DELEGATED HOUSEHOLDER DECISION

Item No.	Report of the Head of Development Management and Building Control	
Address:	124 ROSEVILLE ROAD HAYES	
Development:	Erection of a part single part two storey extension to rear. Erection of a front porch.	
LBH Ref Nos:	7123/APP/2023/3466	
Drawing Nos:	Location Plan 124 01 - Existing Plans 124 02 - Proposed Plans	
Date Plans received:	30-11-23	Date(s) of Amendments(s):
Date Application valid	30-11-23

Proposed Plans

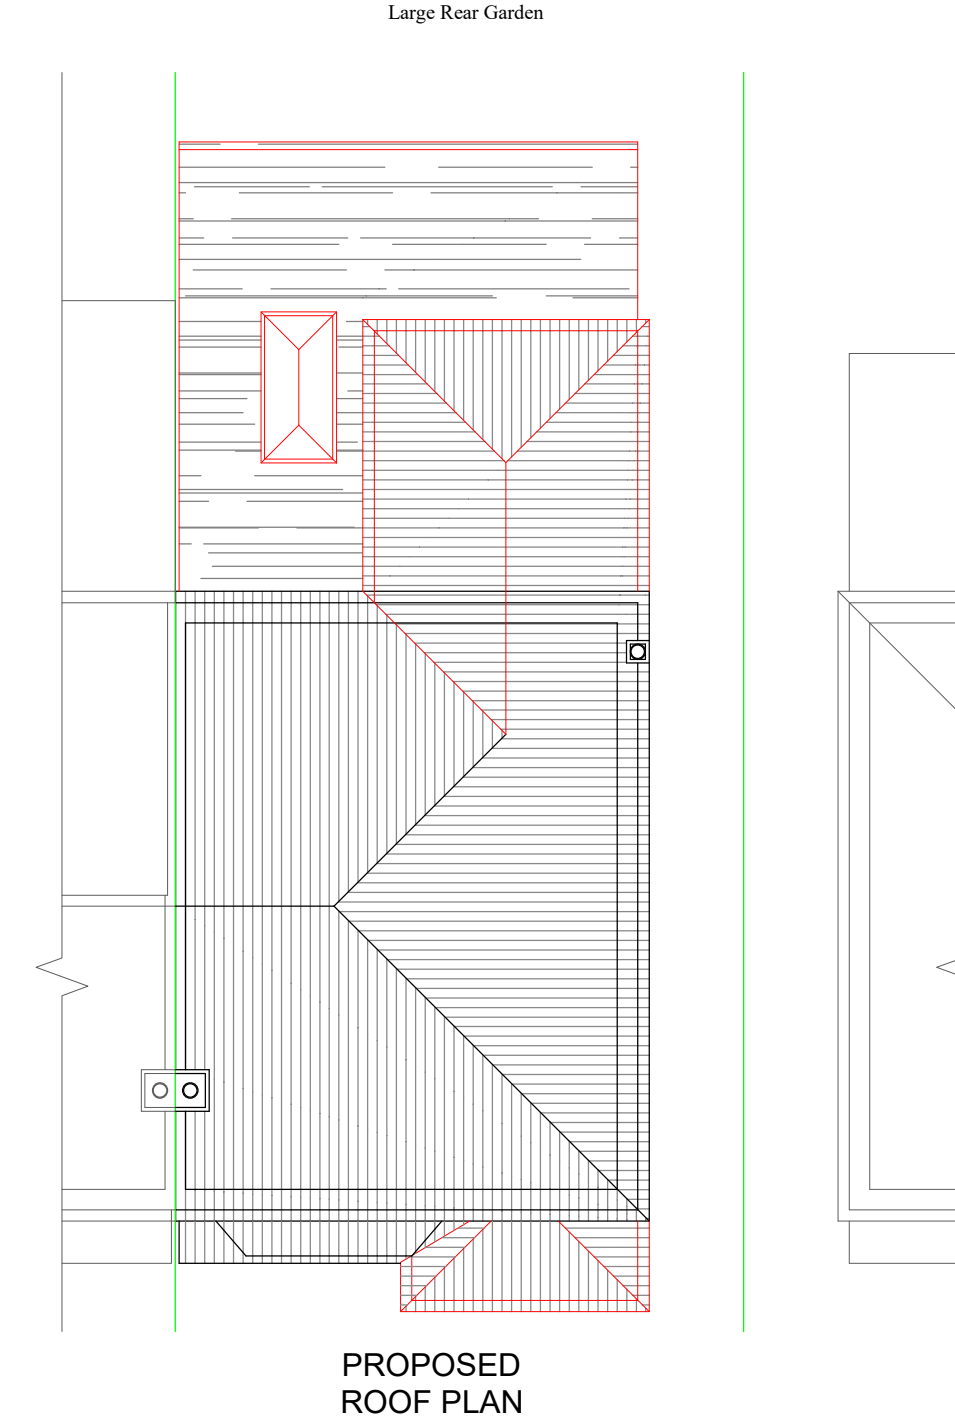
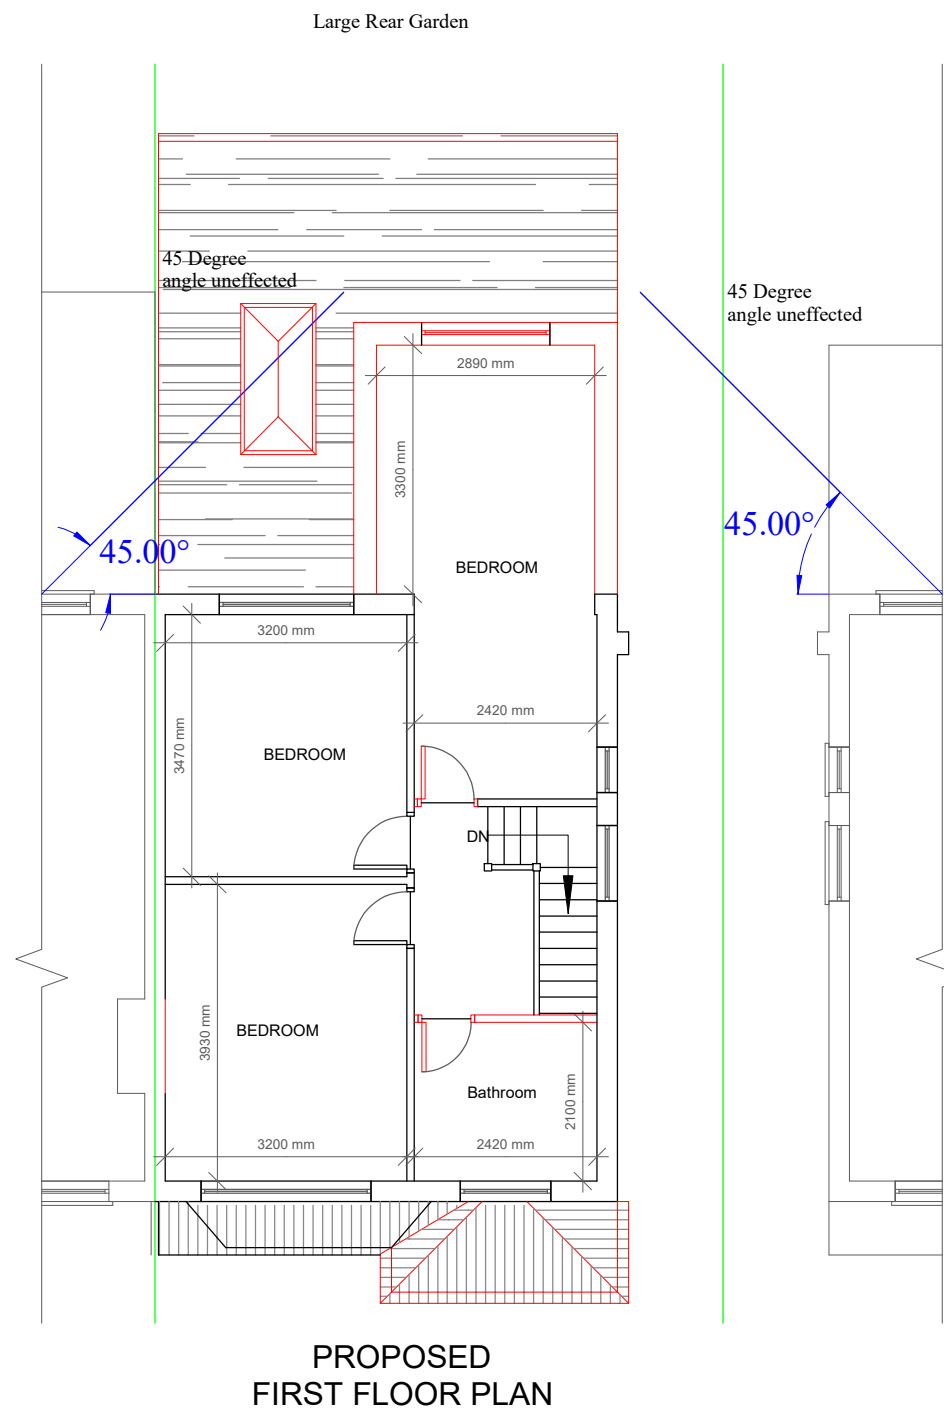
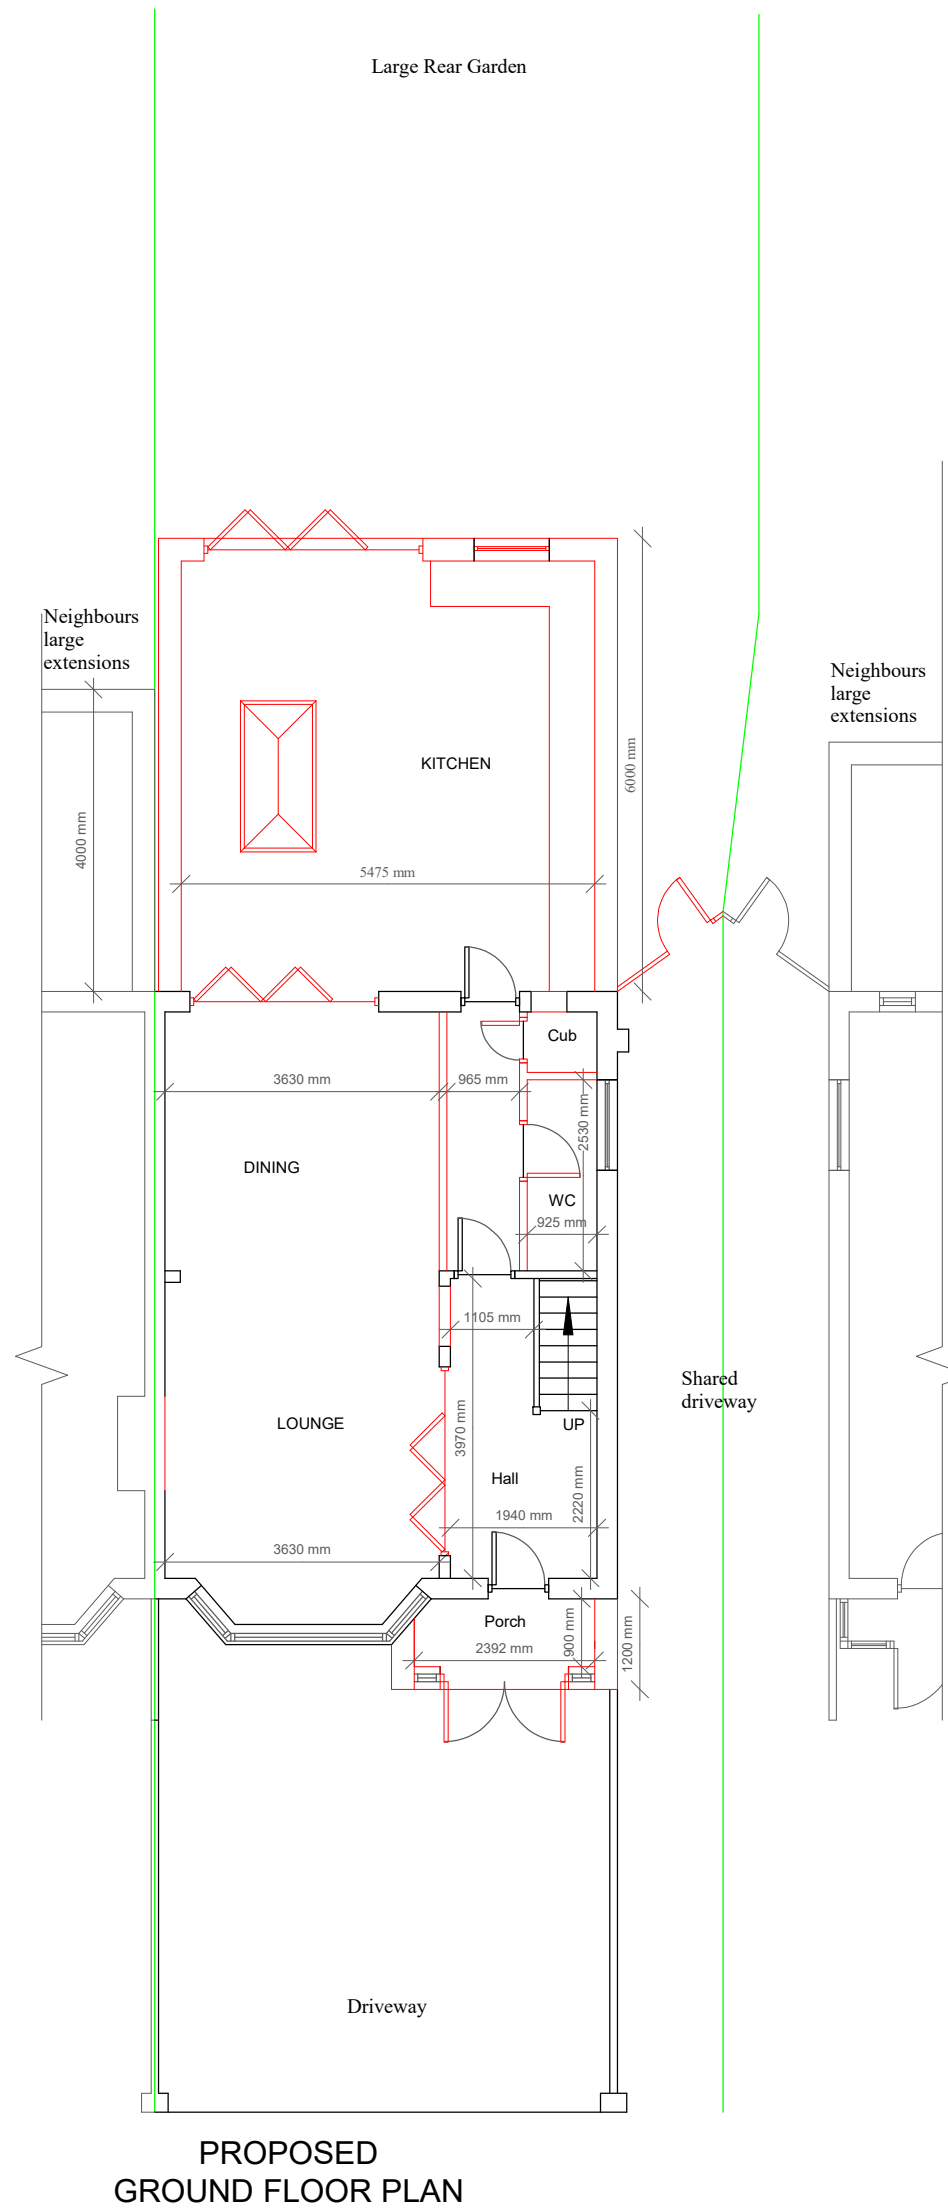
With regards to the single storey part of the rear extension, with a depth of 6.00m, the extension would be well in excess of the 3.60m recommended in Policy DMHD 1 of the Hillingdon Local Plan: Part Two - Development Management Policies (2020). It is considered that the extension would not be a subordinate addition to the dwelling and would result in harm to the character and appearance of the host dwelling and wider area.

With regards to the first floor part of the rear extension, it is noted that with a width of 3.50m, and a depth of 3.60m, the proposal would not interrupt the 45 degree lines of sight from the closest neighbouring first floor windows and would have a ridgeline set down from the main ridgeline of the original roof. This element of the proposal would be considered to accord with all criteria set out in Policy DMHD 1 of the Hillingdon Local Plan: Part Two - Development Management Policies (2020).

With regards to the front porch extension, with a modest width and depth, the proposal would be considered a minor addition to the front elevation of the dwelling and would not be considered to cause any undue harm to the character and appearance of the host dwelling or wider area, in accordance with Policy DMHD 1 of the Hillingdon Local Plan: Part Two - Development Management Policies (2020).

The proposed single storey rear extension, by reason of its excessive depth, width, and overall size, would result in a disproportionate addition that would not appear subordinate to the appearance of the original dwelling. The proposal would therefore not be in accordance with Policy BE1 of the Hillingdon Local Plan: Part One Strategic (2012) and Policies DMDH 1, DMHB 11 and DMHB 12 of the Hillingdon Local Plan: Part Two - Development Management Policies (2020), in this respect.
